Attention: Junction Rivers Wind Farm – SSD 30448824

Thank you for the opportunity to provide a submission to the Junction Rivers Wind Farm Project – SSD 30448824 located at Moulamein.

Figure 2 - Blade Diagram Swept Path (100 Metre blade case study)

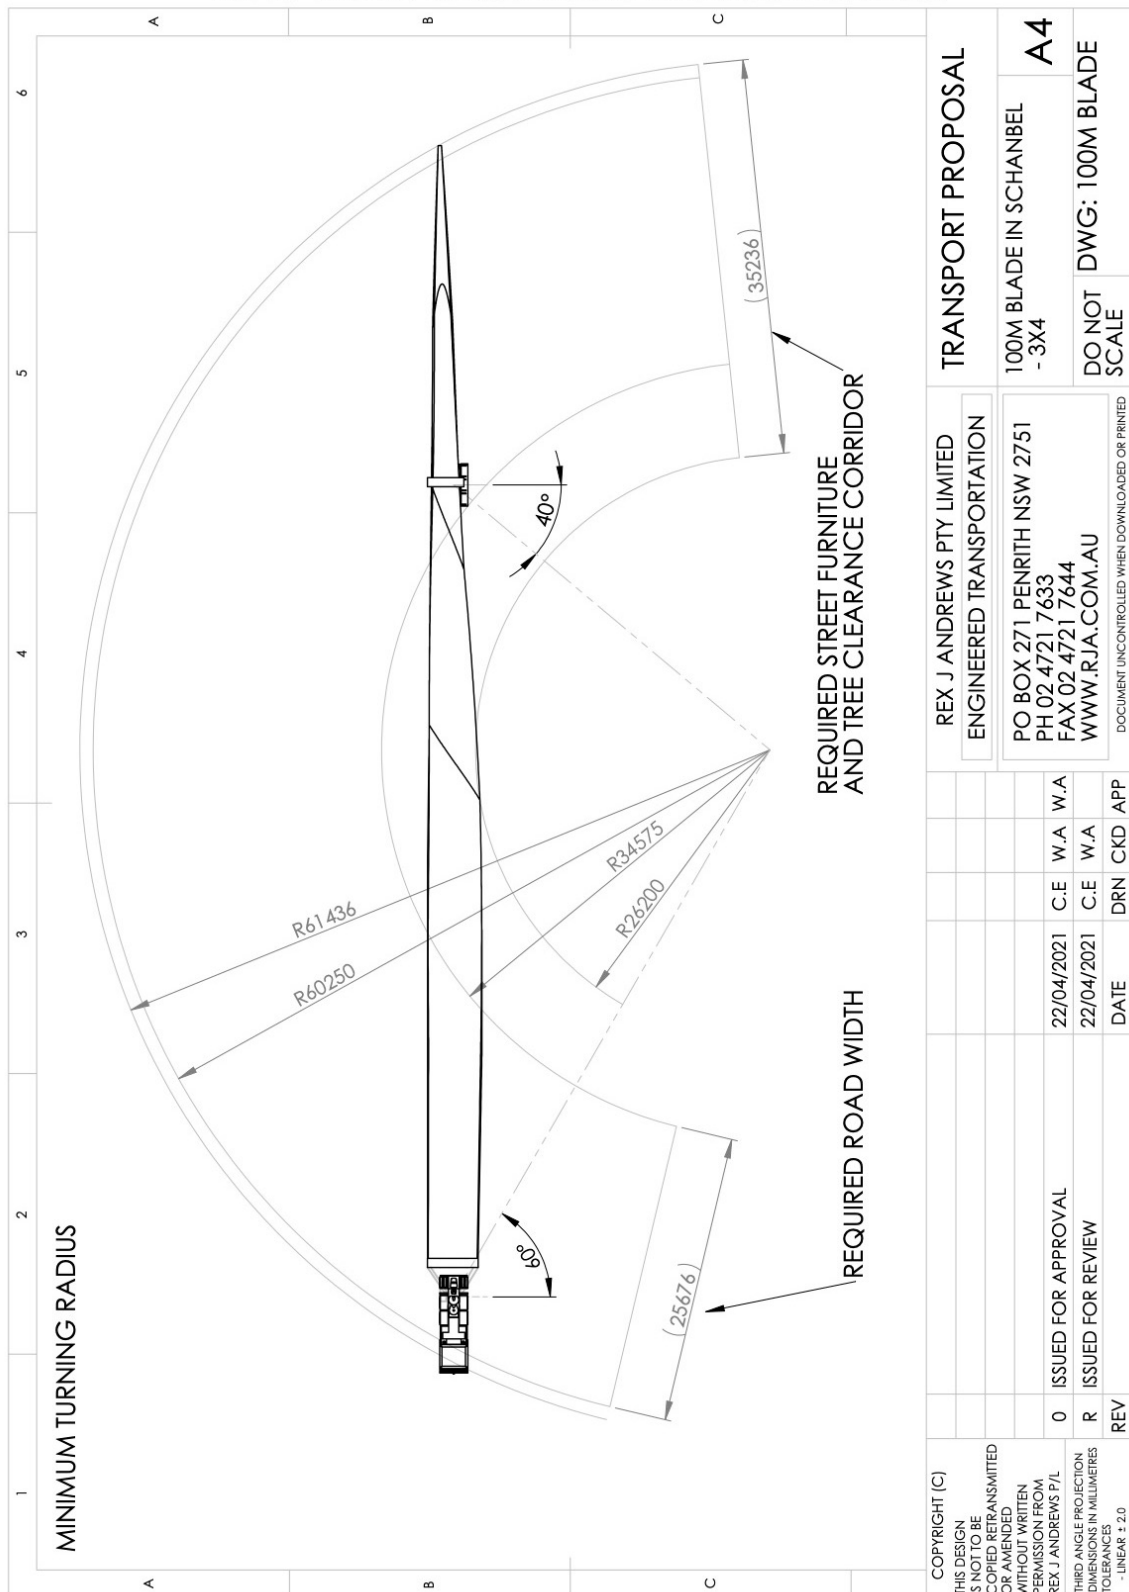
Emergency parking locations have been identified in the Route Study however appear inadequate. The blade OSOM vehicles are up to 110m long and are longer than some emergency parking locations. The OSOM route assessment must be revised to include locations of pull-over bays, laybys and emergency stopping on the route and identify types of high-risk OSOM that will utilise each facility.

A swept path analysis for the largest high-risk OSOM vehicle demonstrating the largest high-risk OSOM can physically enter, exit and park within a rest area or pull over locations without impacting access and parking for other vehicles permitted to access these locations.
